## **Oxfordshire County Council's response to Cherwell District Council's consultation on Phase One North West Bicester Eco-town (application: 10/01780/HYBRID)**

Daniel Round  
Linda Currie  
03.02.2011

Figure 3 – Bridge 1 & 2 Design Drawings

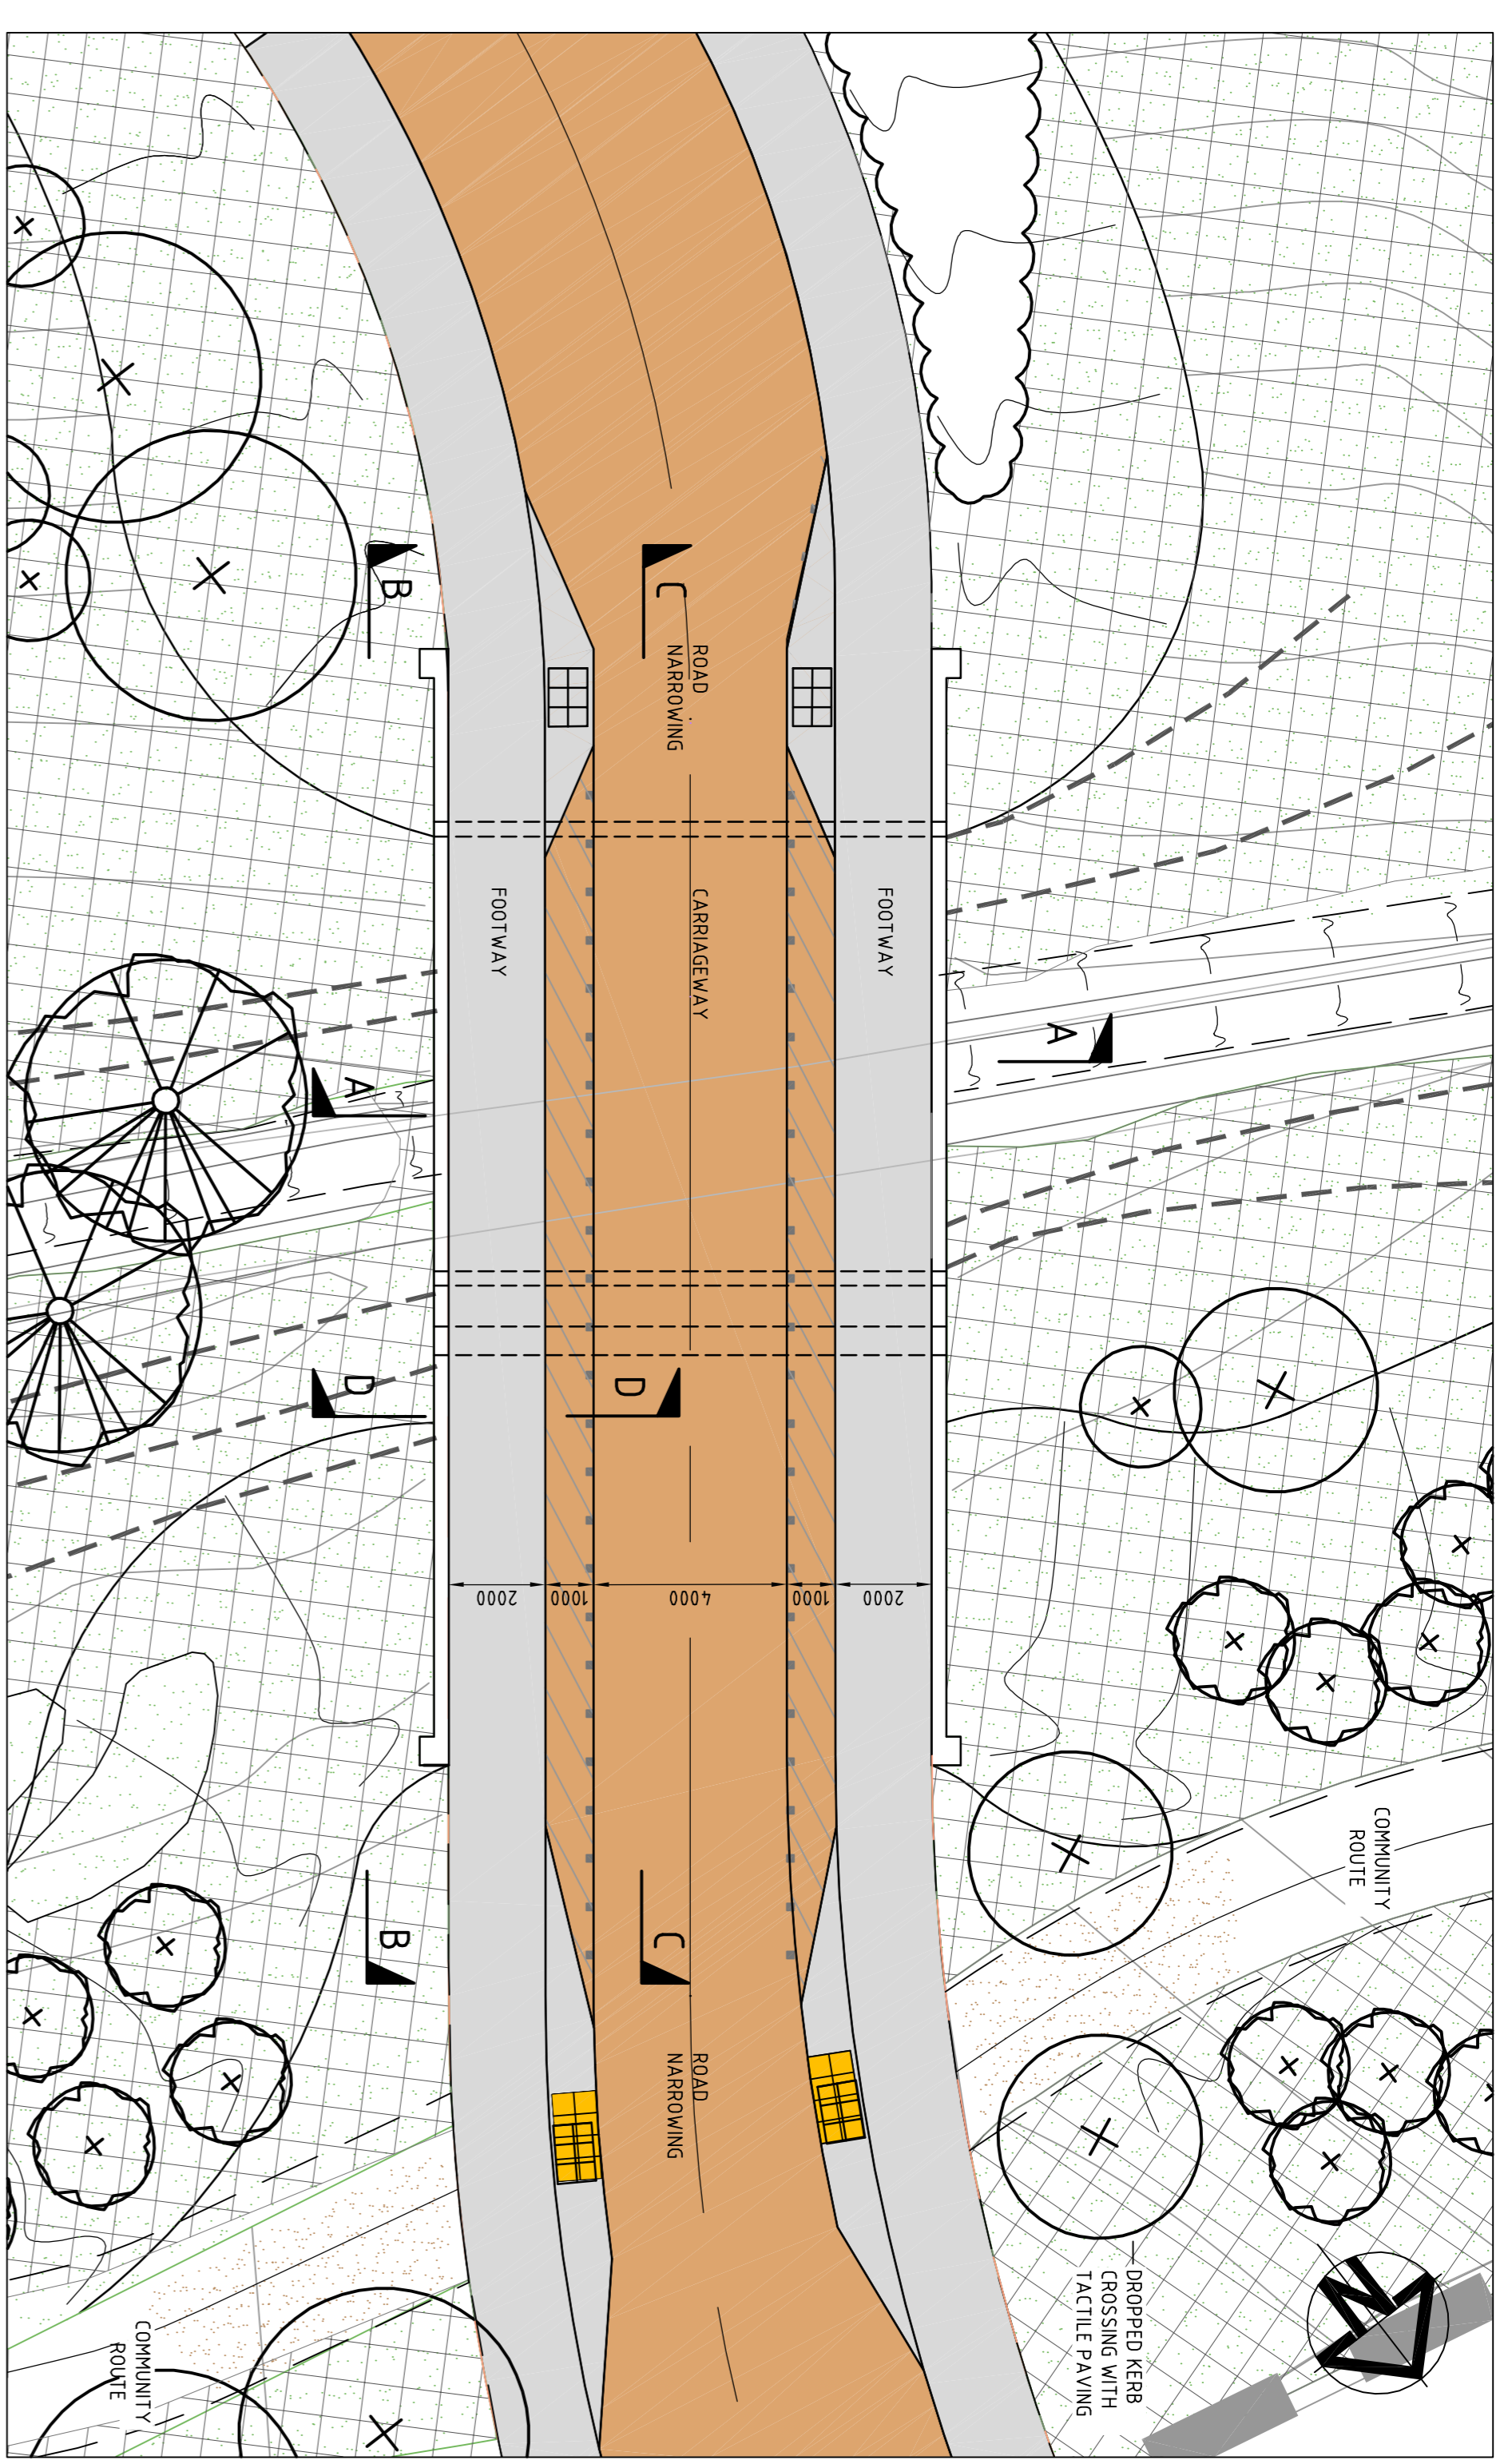
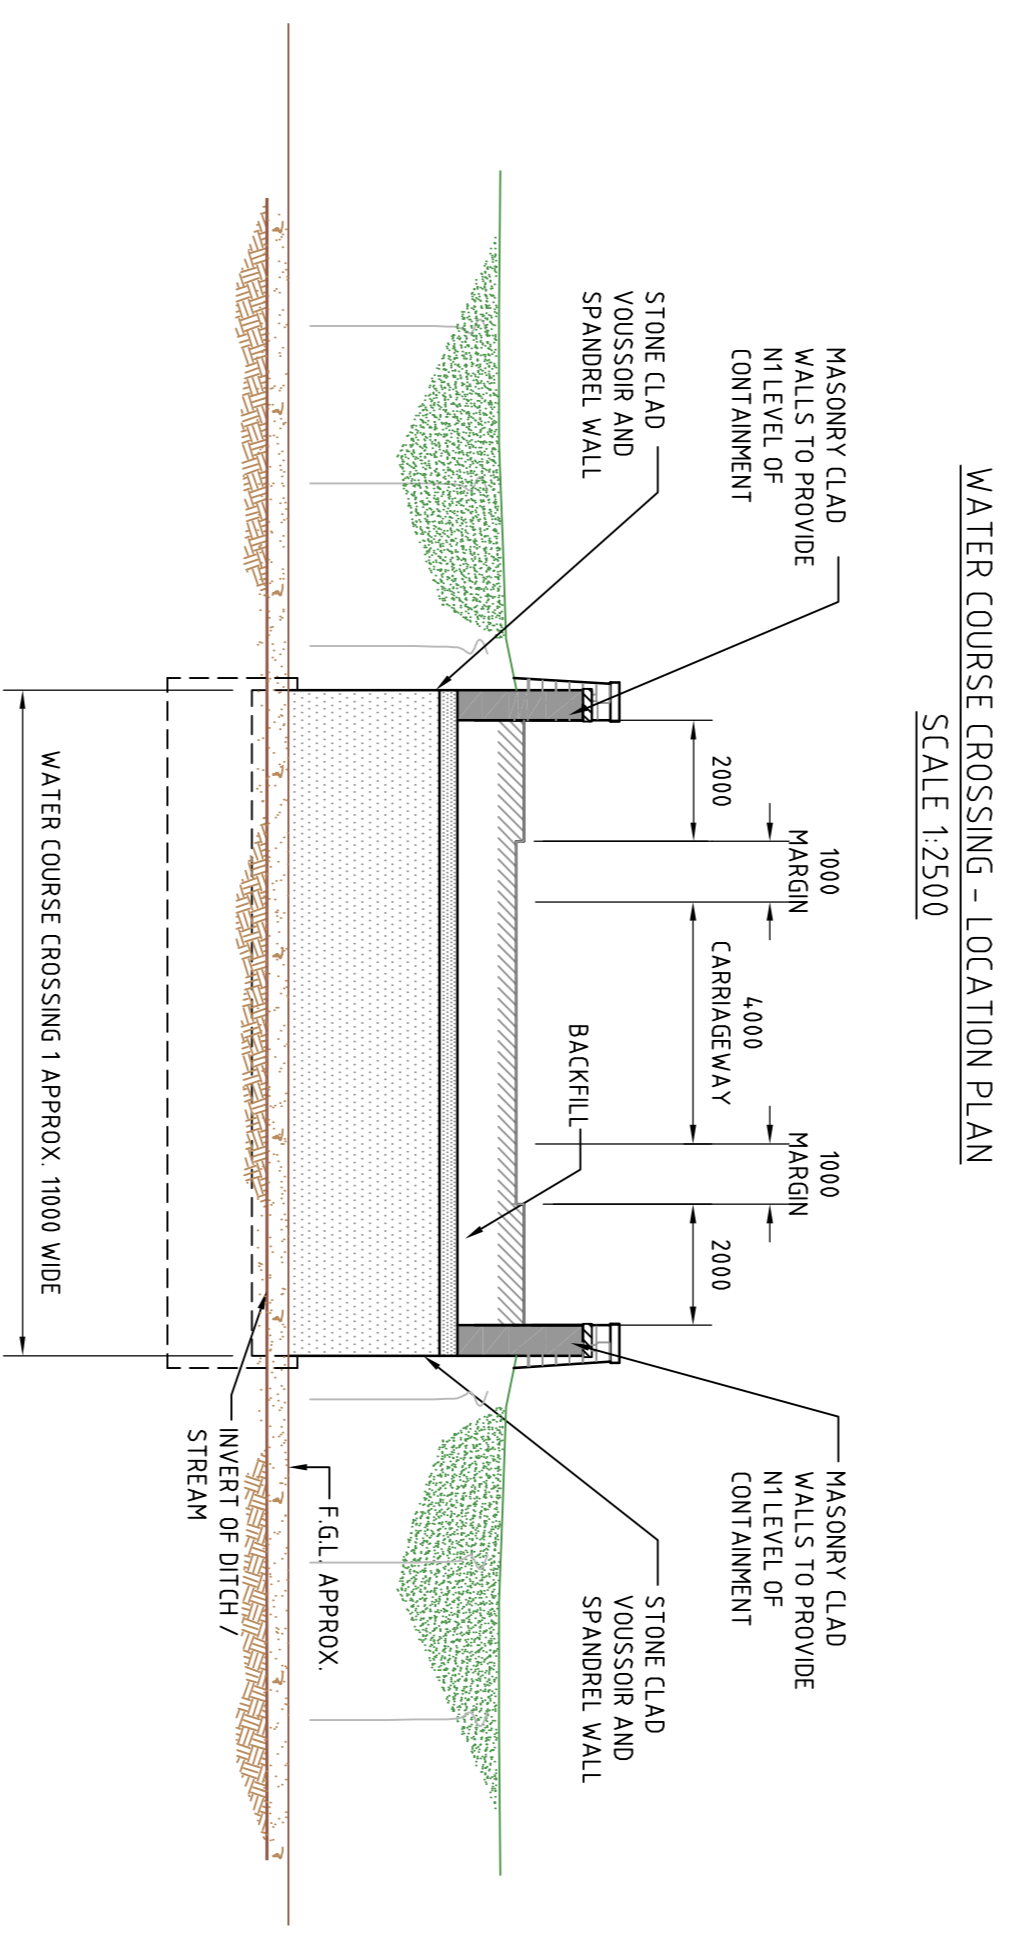
24. The two bridges proposed within the site appear to be structurally sound, but the functional appearance is a missed opportunity to create an architectural statement that is exemplary in its design. Further details are required before “Approved In Principle” (AIPs) plans can be issued for their implementation. This must be a planning condition imposed by CDC.

25. **Recommendation: SUPPORT** subject to adequate information being submitted in order for AIPs to be issued and discharge of an appropriate planning condition.
